Our Ref: AB/64/19/CLP
Your Ref:

Application for Lawful Development Certificate for a Proposed Use or Development

Development Lawful development certificate for a proposed wooden cedar summerhouse in rear garden.
Location 102 Fitzalan Road Arundel

NOT TO SCALE

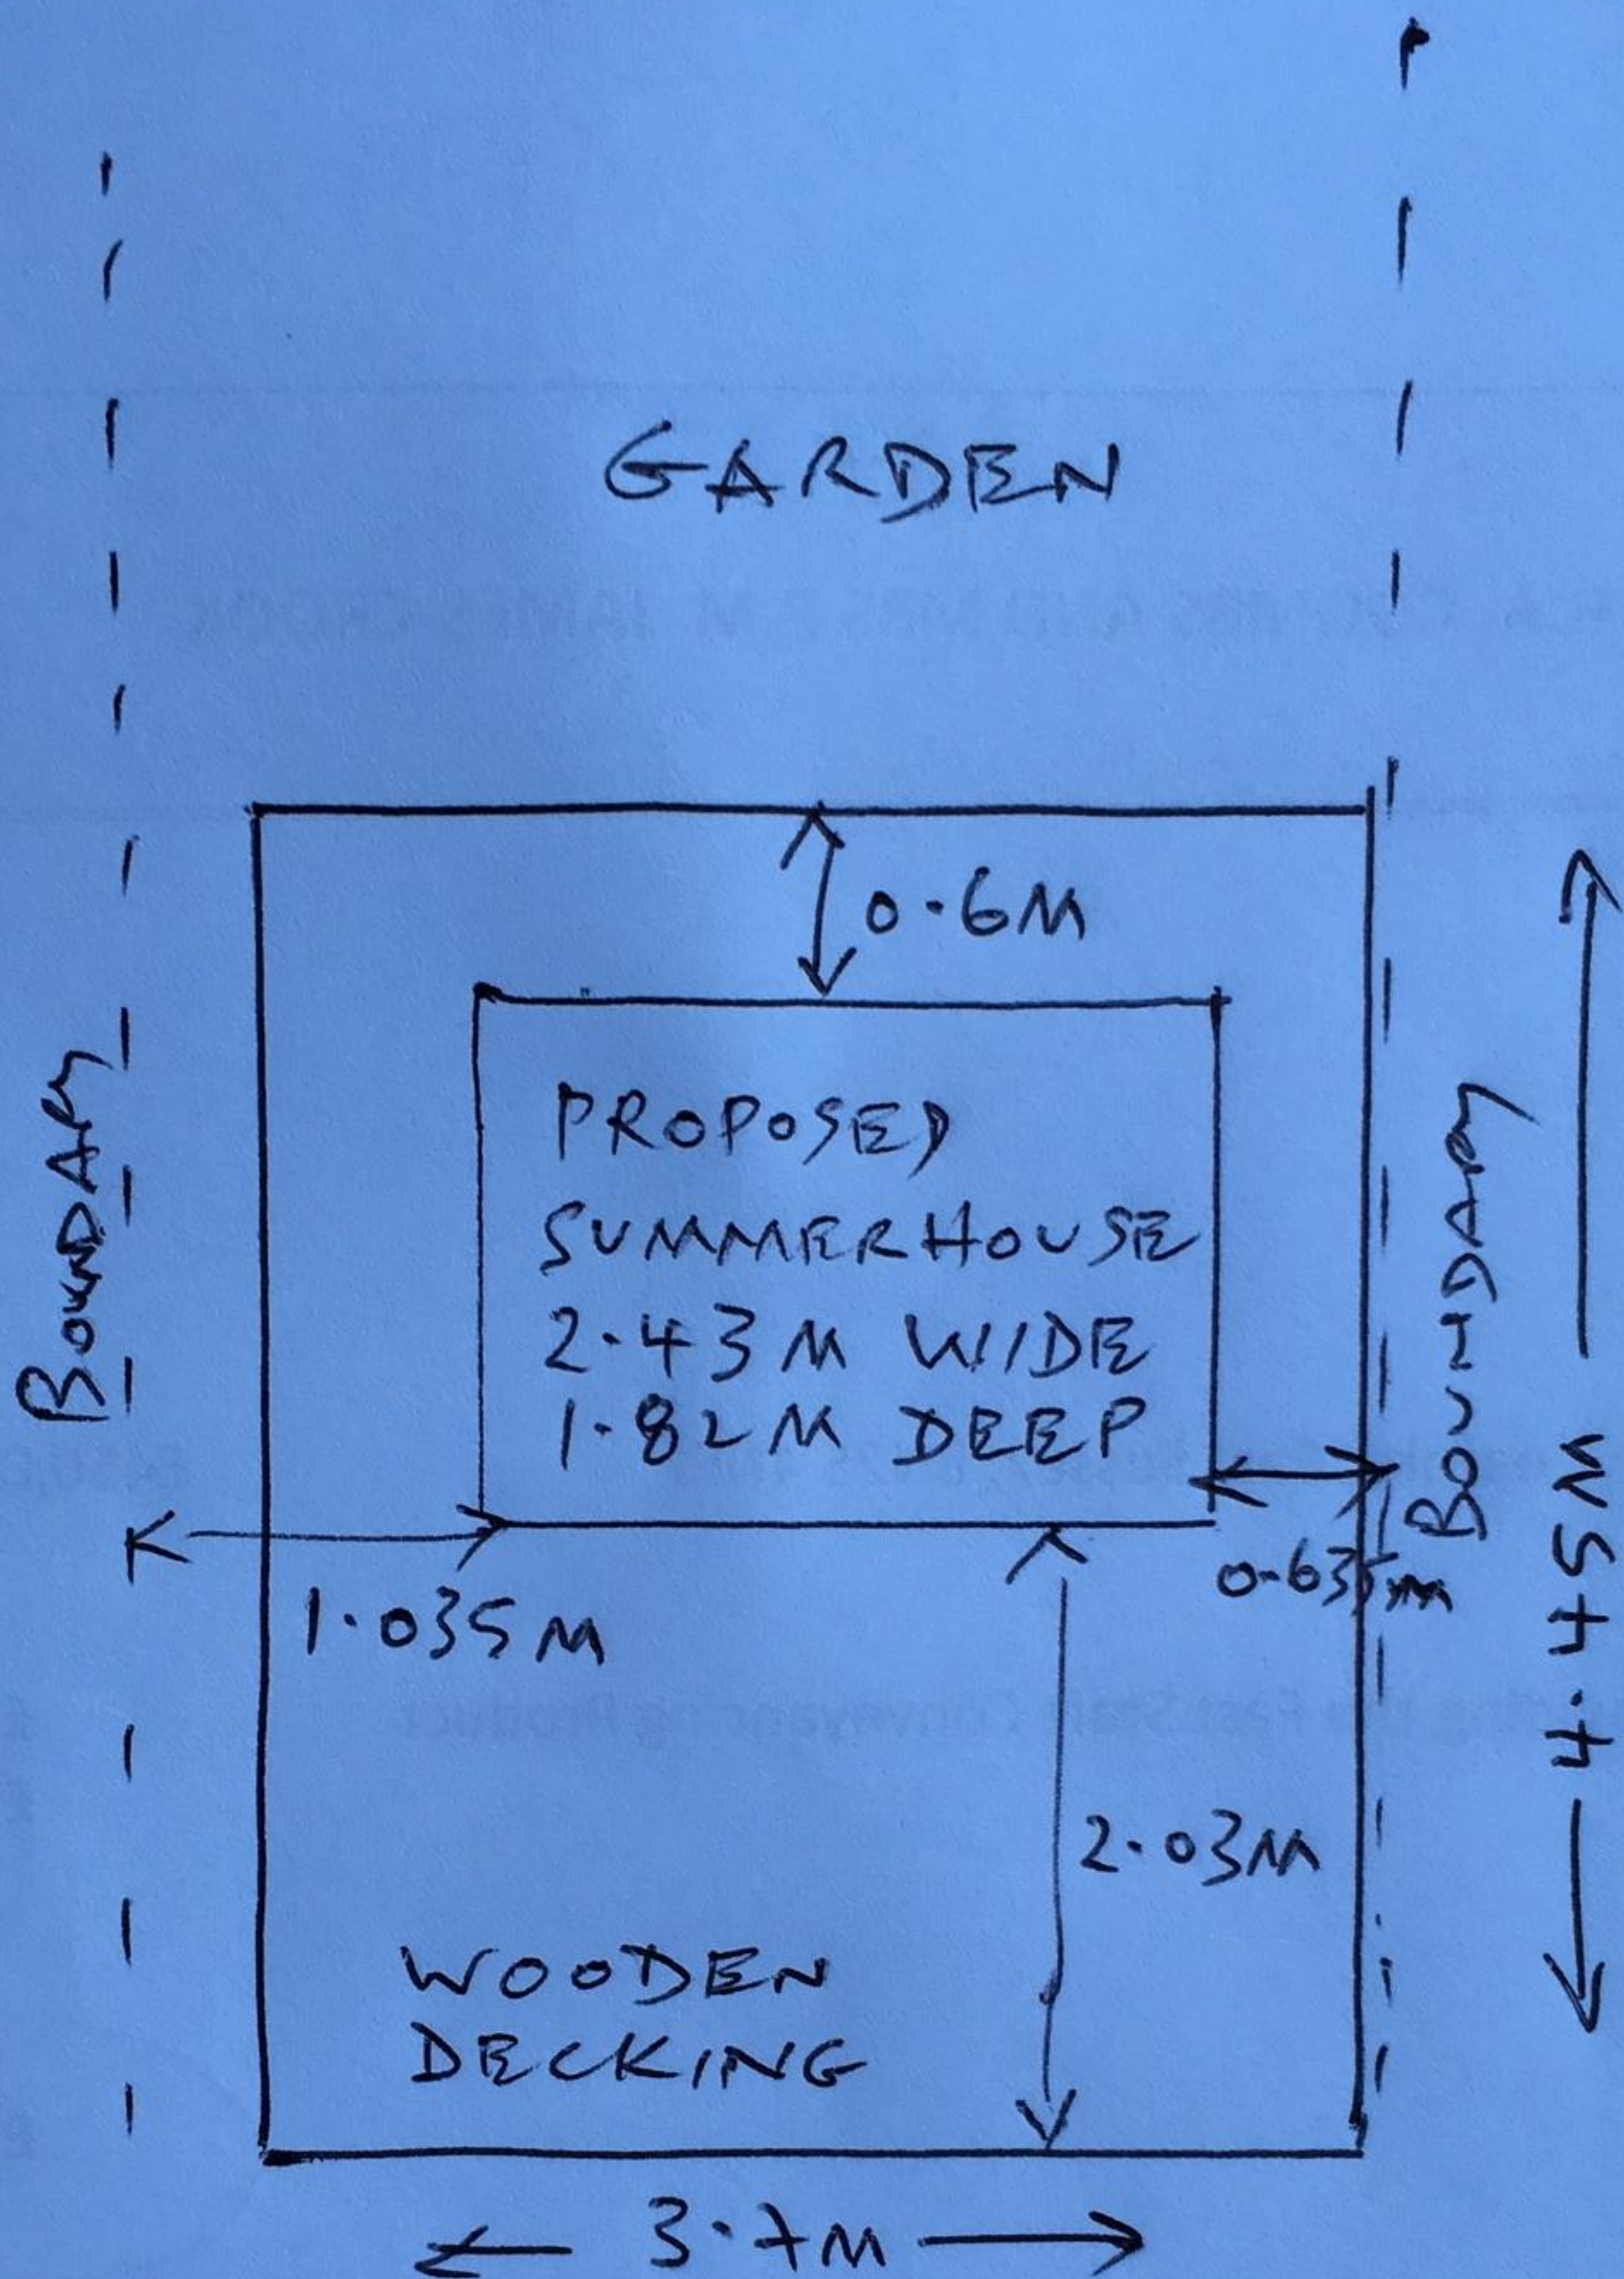
Please amend plan to clearly show the boundary of the property with a red edge.

Please annotate the location of proposed summerhouse in rear garden and provide measurements to each boundary.
